CITY OF ALBUQUERQUE

August 13, 2019

RE: **7901 Las Lomas NE**
Grading Plan Stamp Date: 7/29/19
Drainage File: D16D002I

Based on the submittal received on 8/7/19, the grading plan cannot be approved until the following corrections are made:

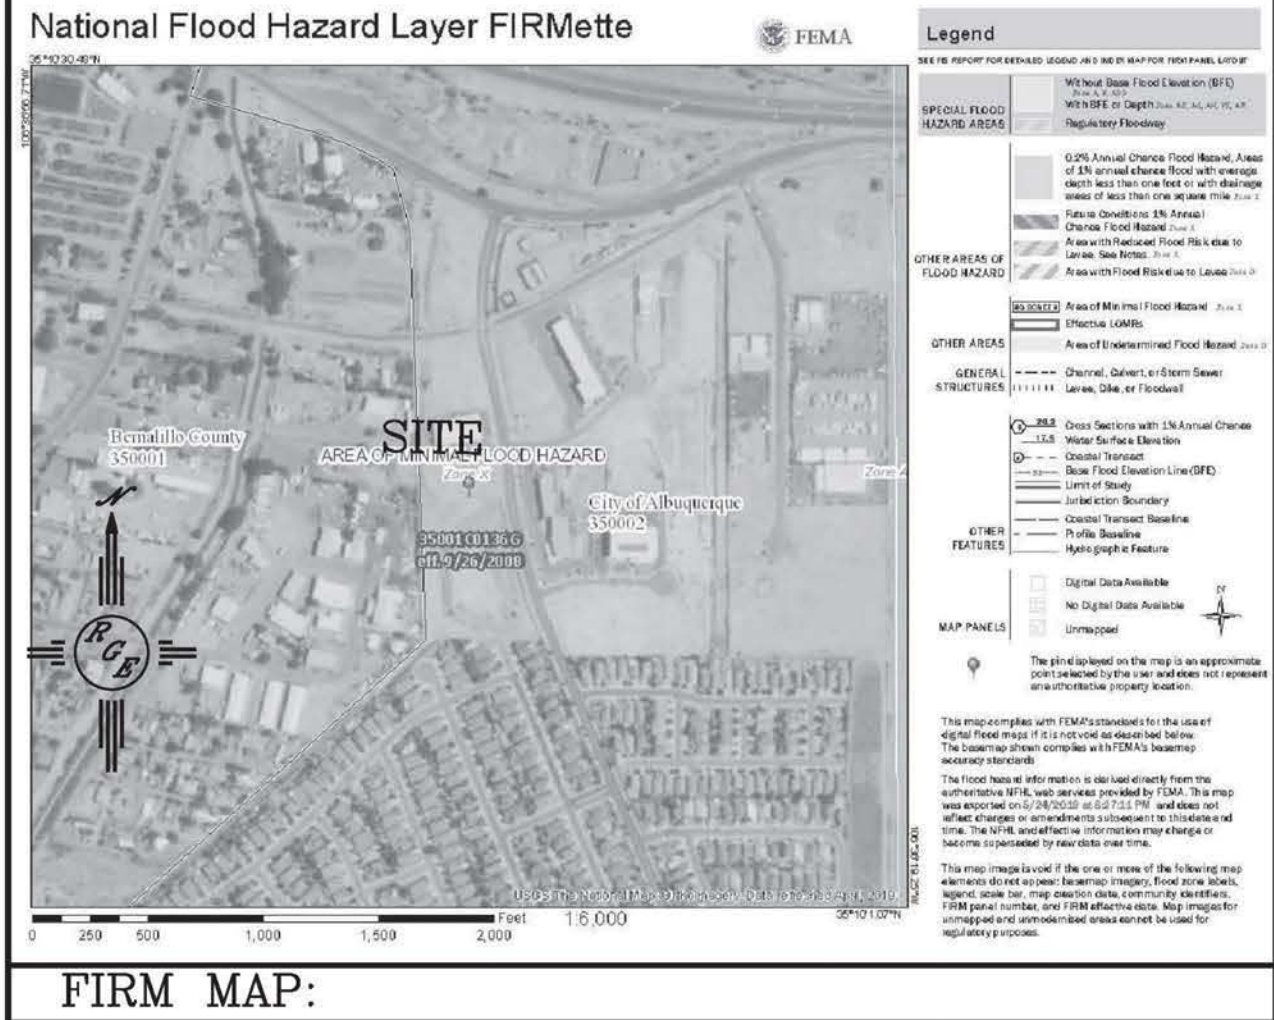
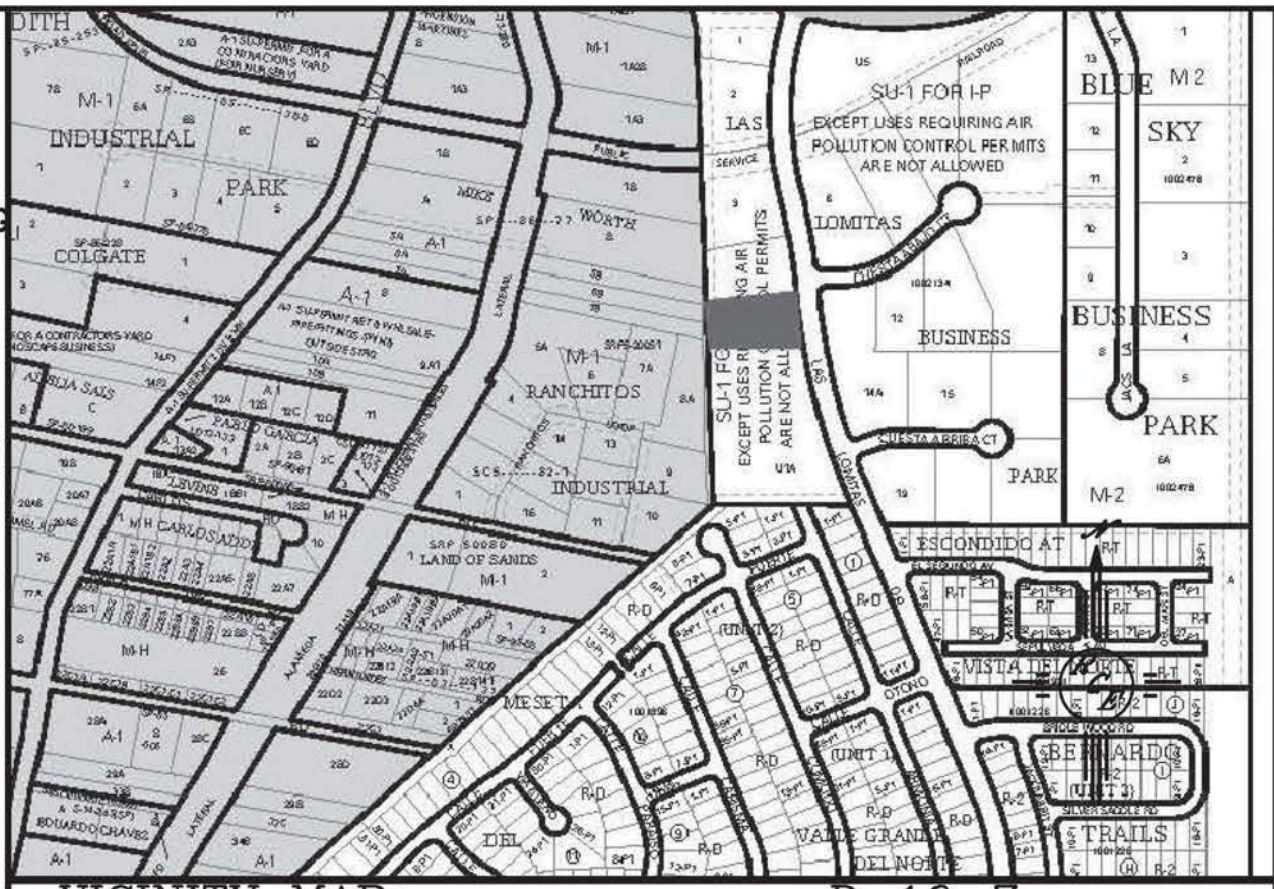
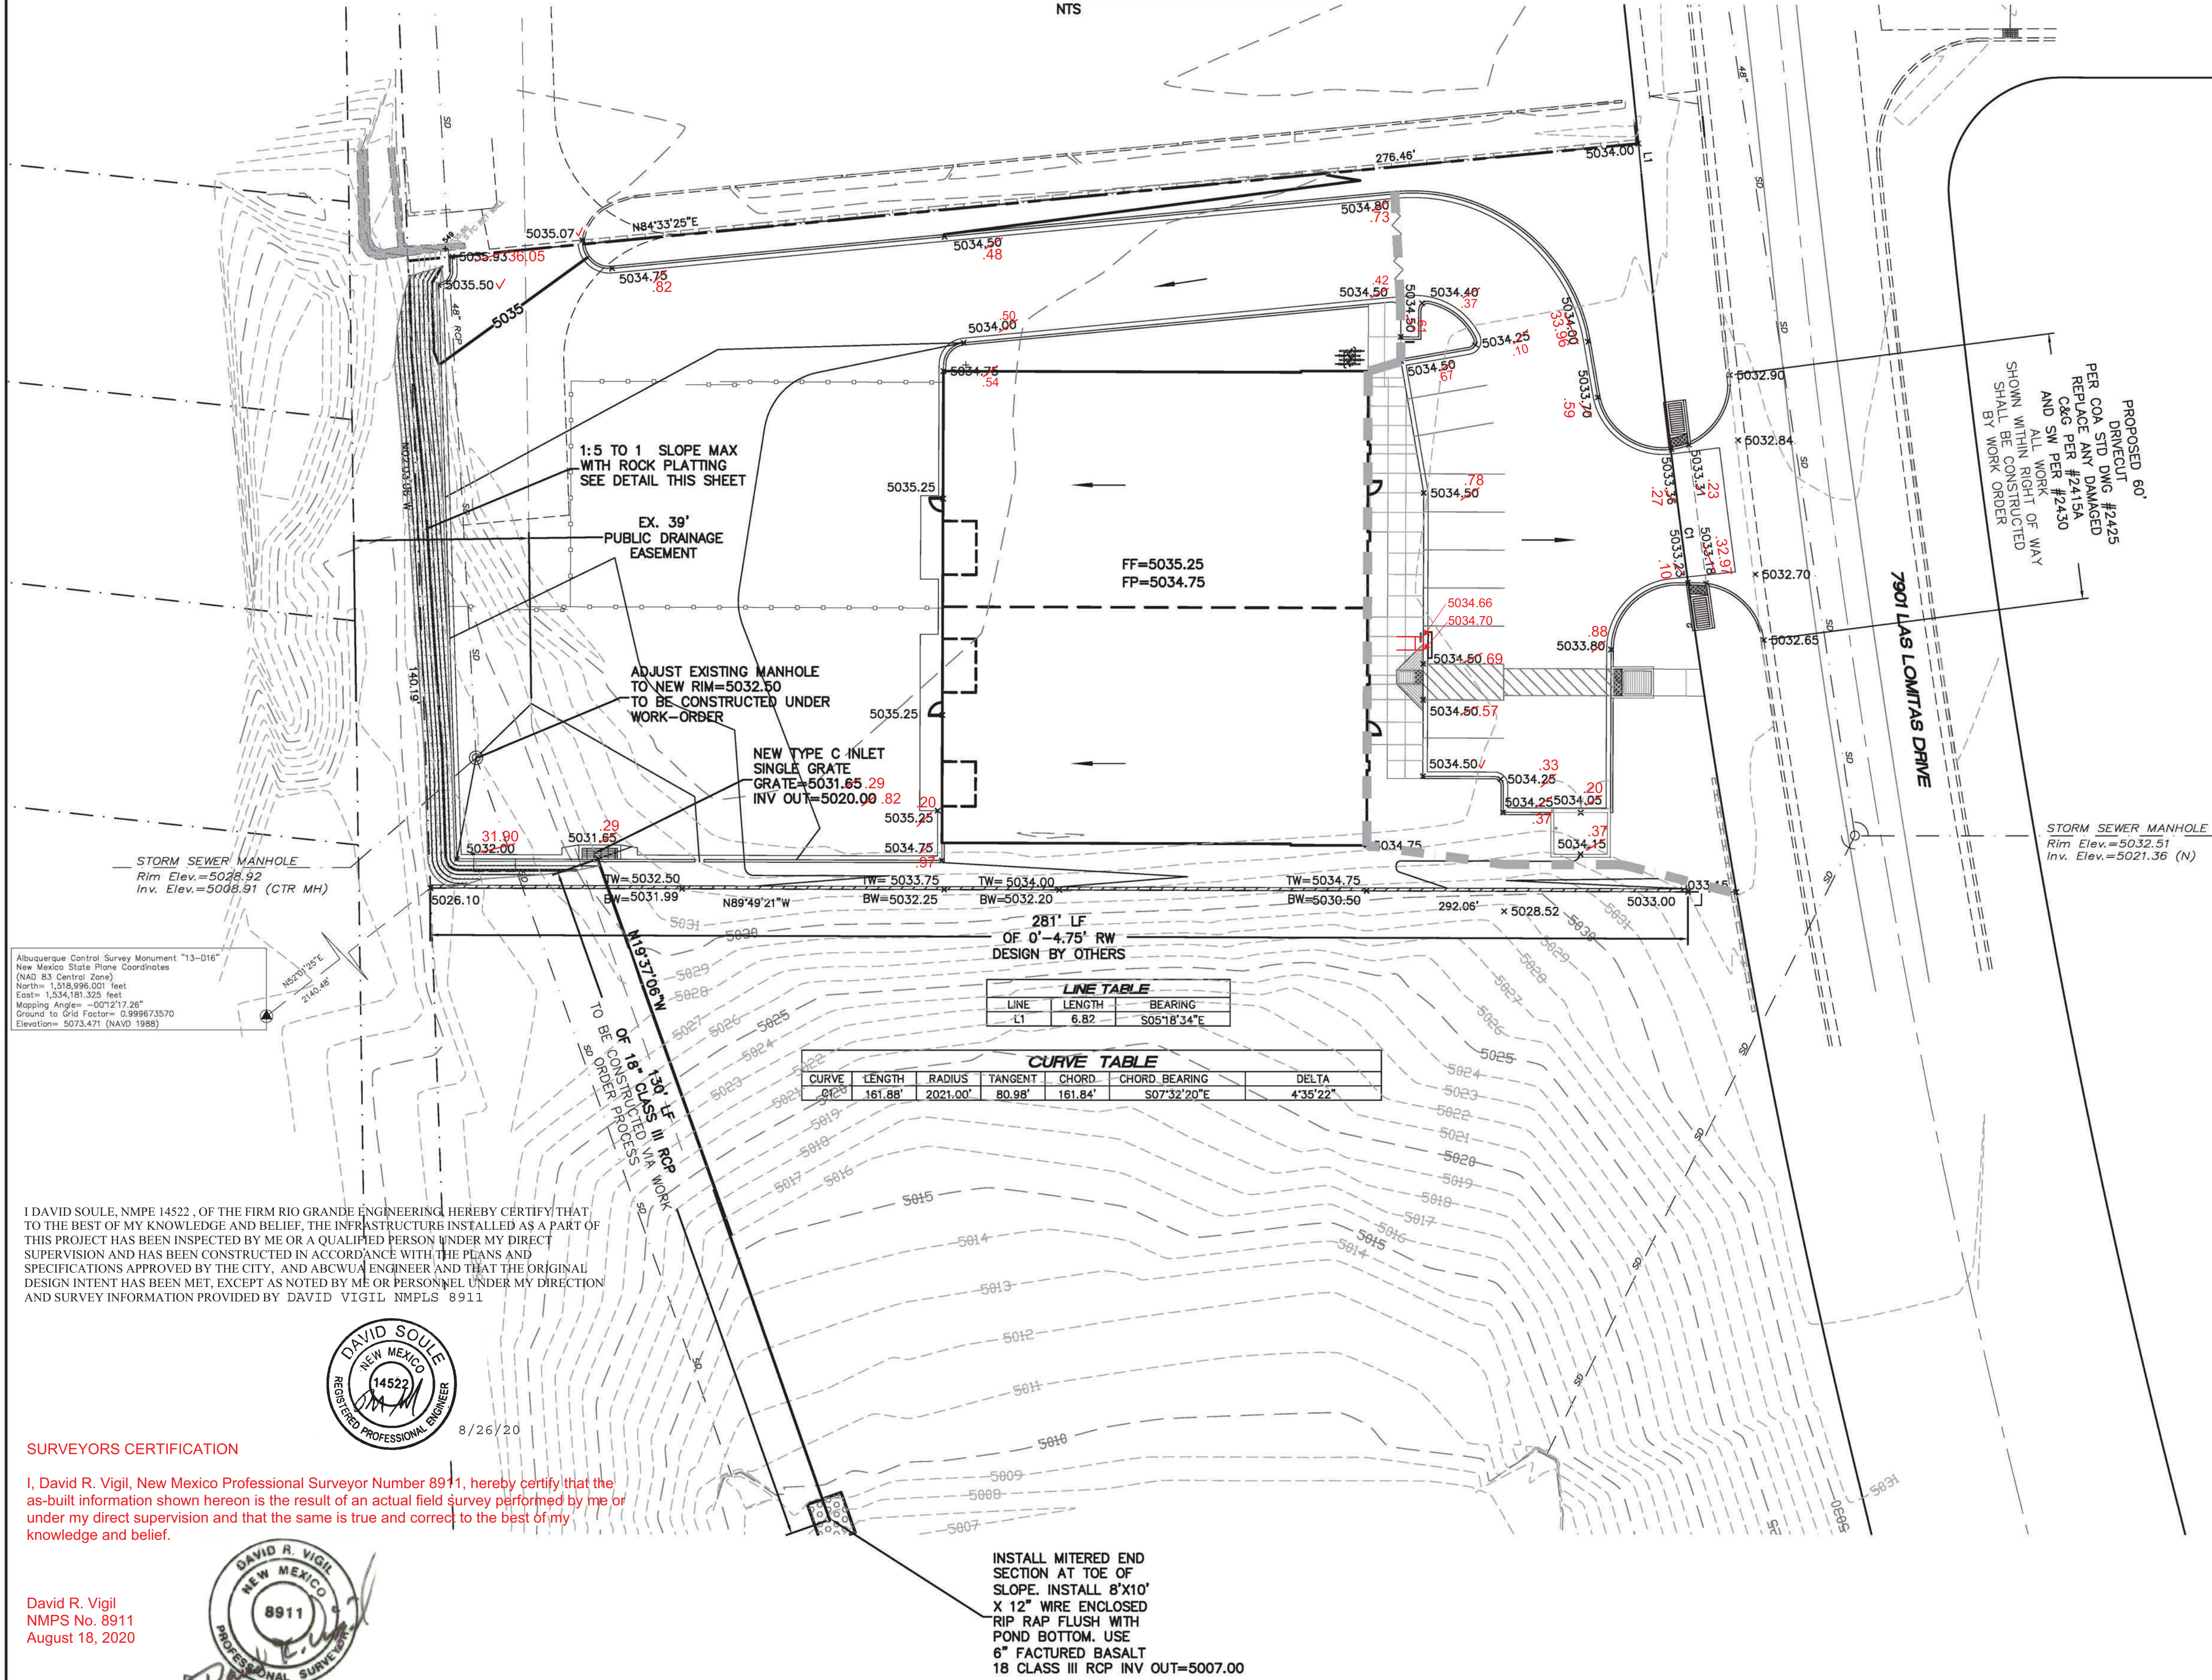
1. Show the public drainage easement for the storm drain. The inlet and private storm drain cannot encroach on the storm drain easement.
2. Show the outlet structure into the pond for the private storm drain line with additional detail to be shown on the work order.

3. Site Hydrology, Hydraulics, and Narrative are missing now.
4. As a reminder, if the project total area of disturbance (including the staging area and any work within the adjacent Right-of-Way) is 1 acre or more, then an Erosion and Sediment Control (ESC) Plan and Owner's certified Notice of Intent (NOI) is required to be submitted to the Stormwater Quality Engineer (Curtis Cherne, PE, ccherne@cabq.gov, 924-3420) 14 days prior to any earth disturbance.
